15 July 2019

File No: 2019/351887  
Our Ref: R/2014/17/M

**One Carrington Street – Wynyard Over-Station Development – Modification 9 (SSD-5824-Mod-9)**

drawing Proposed Shell House Elevations

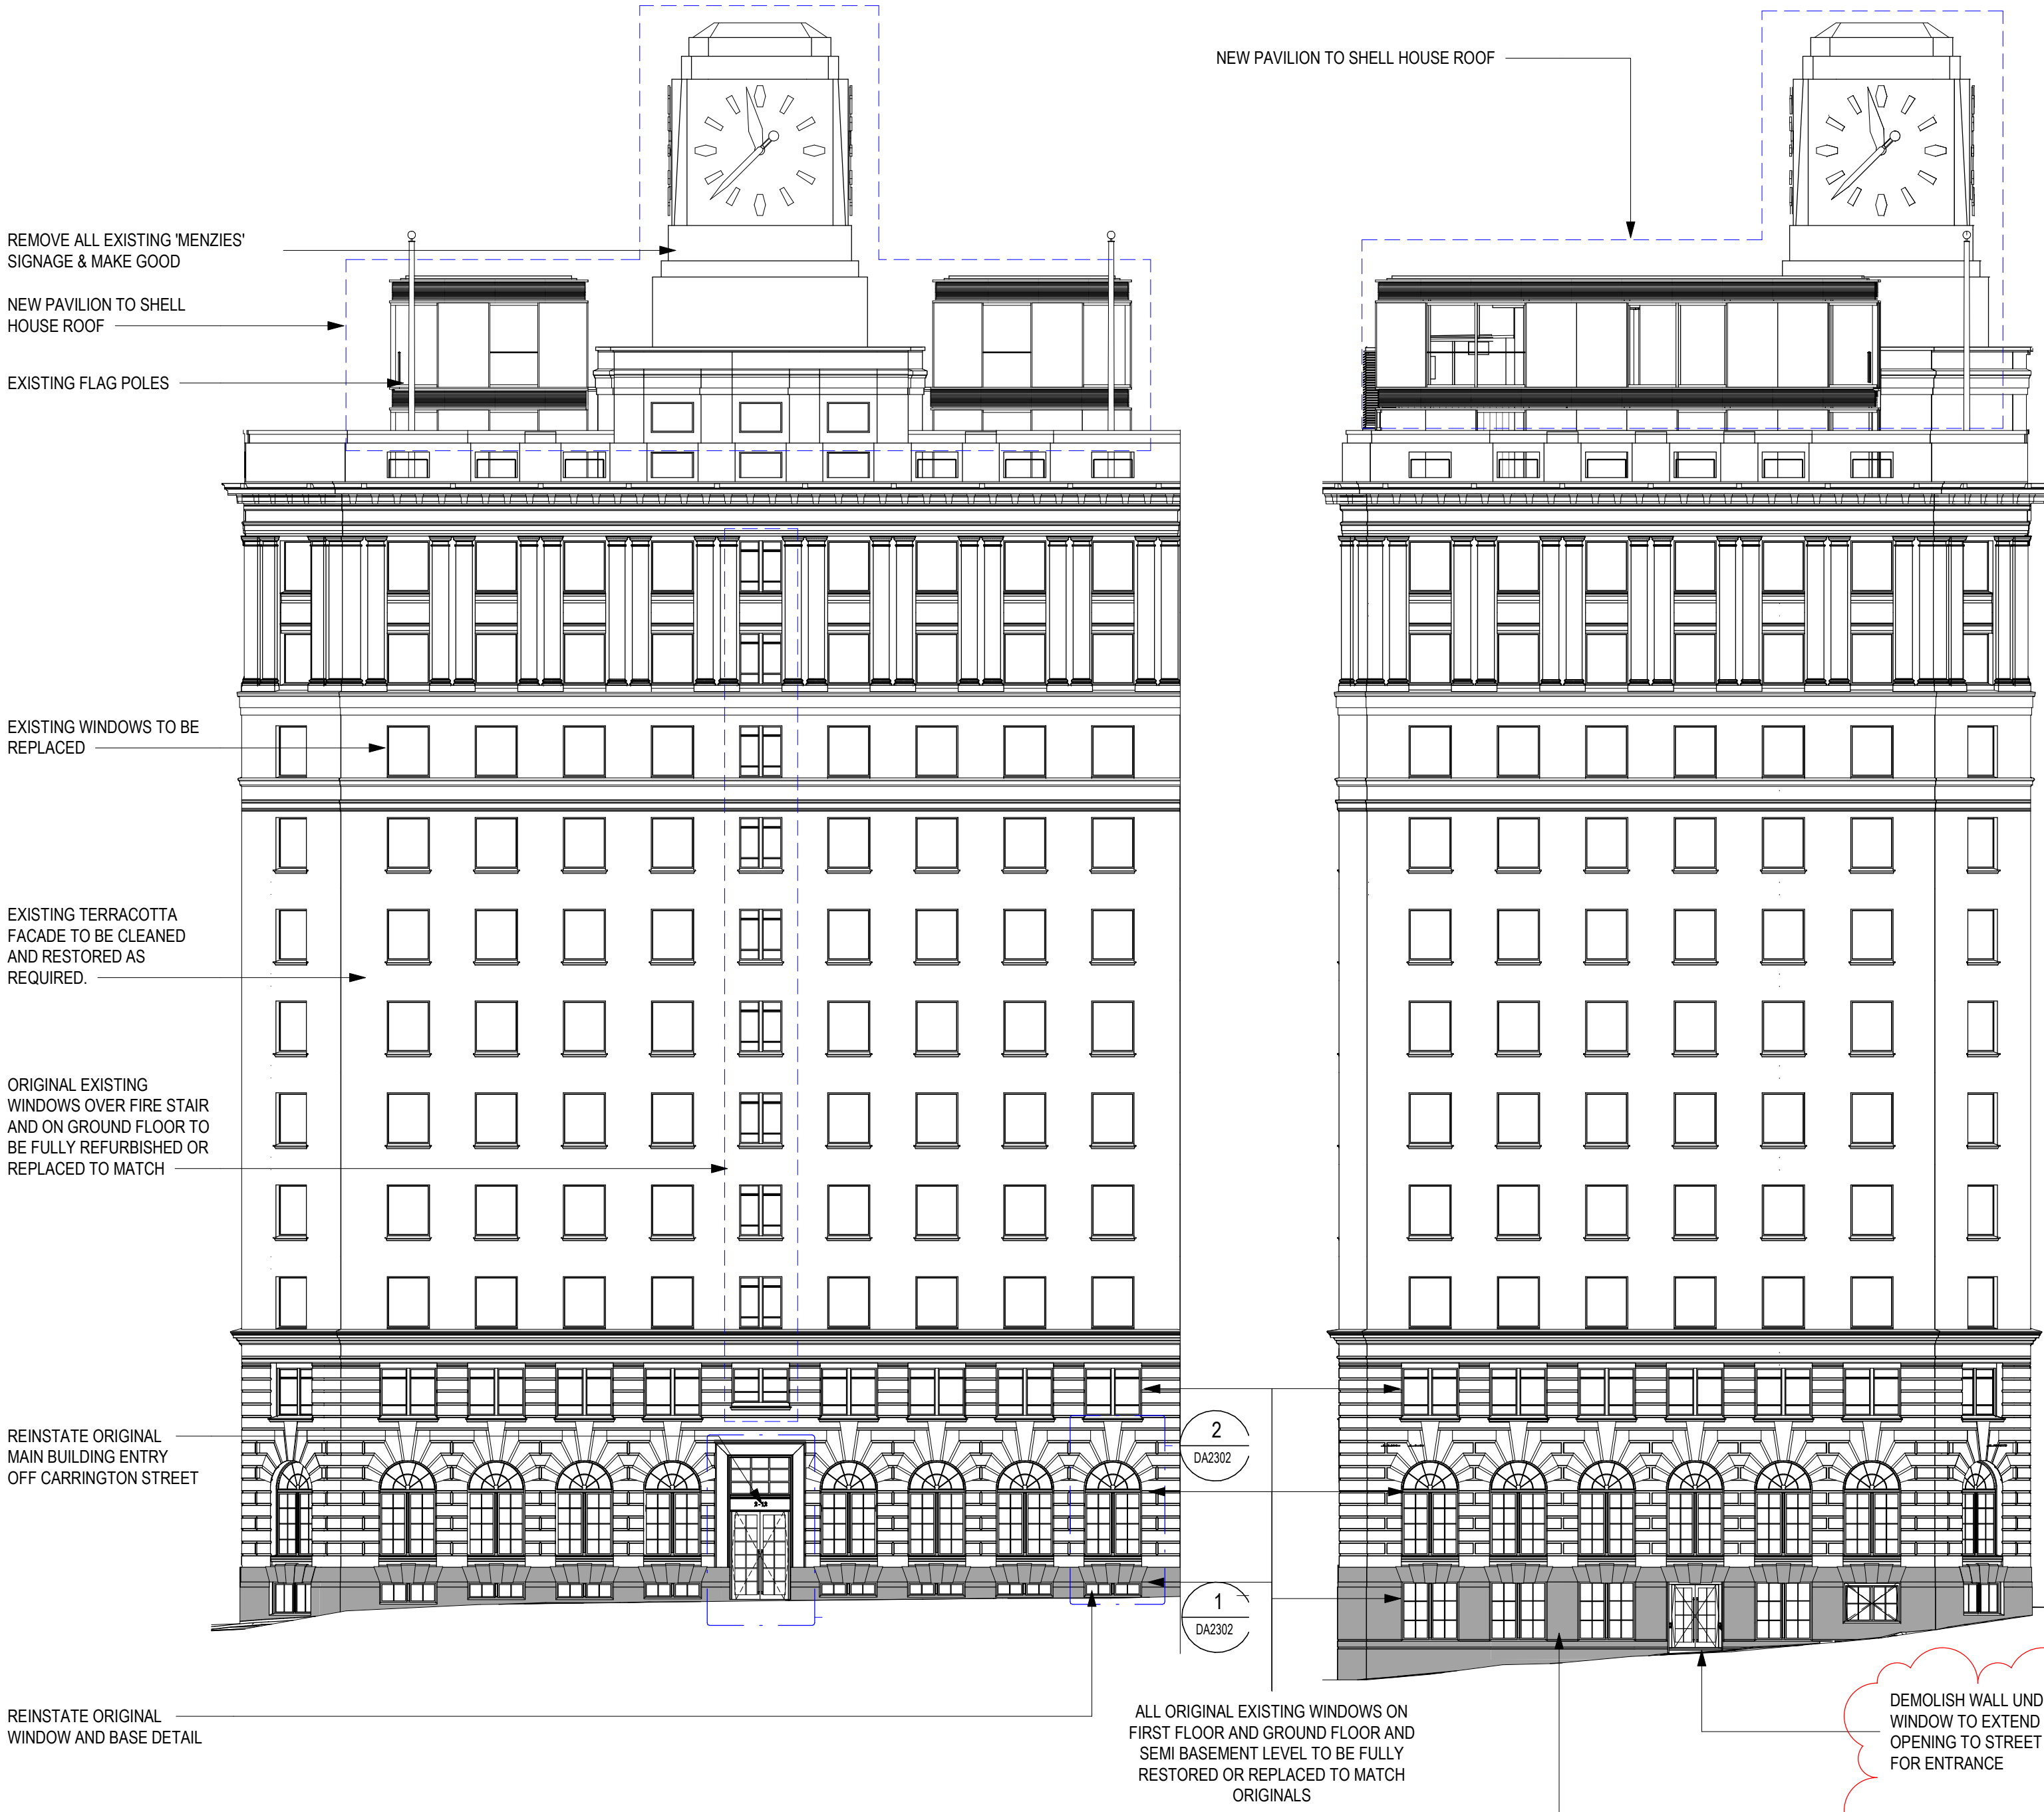
Council staff recommend that, if the application is recommended for approval, the following condition is imposed with regard to the alterations to Shell House:

*Design details of the pier to be reinstated, trachyte base courses and steel windows and new entry door on Margaret St facade are to be submitted to and approved by Council's Area Planning Manager/Area Planning Coordinator prior to commencement of the aforementioned works.*
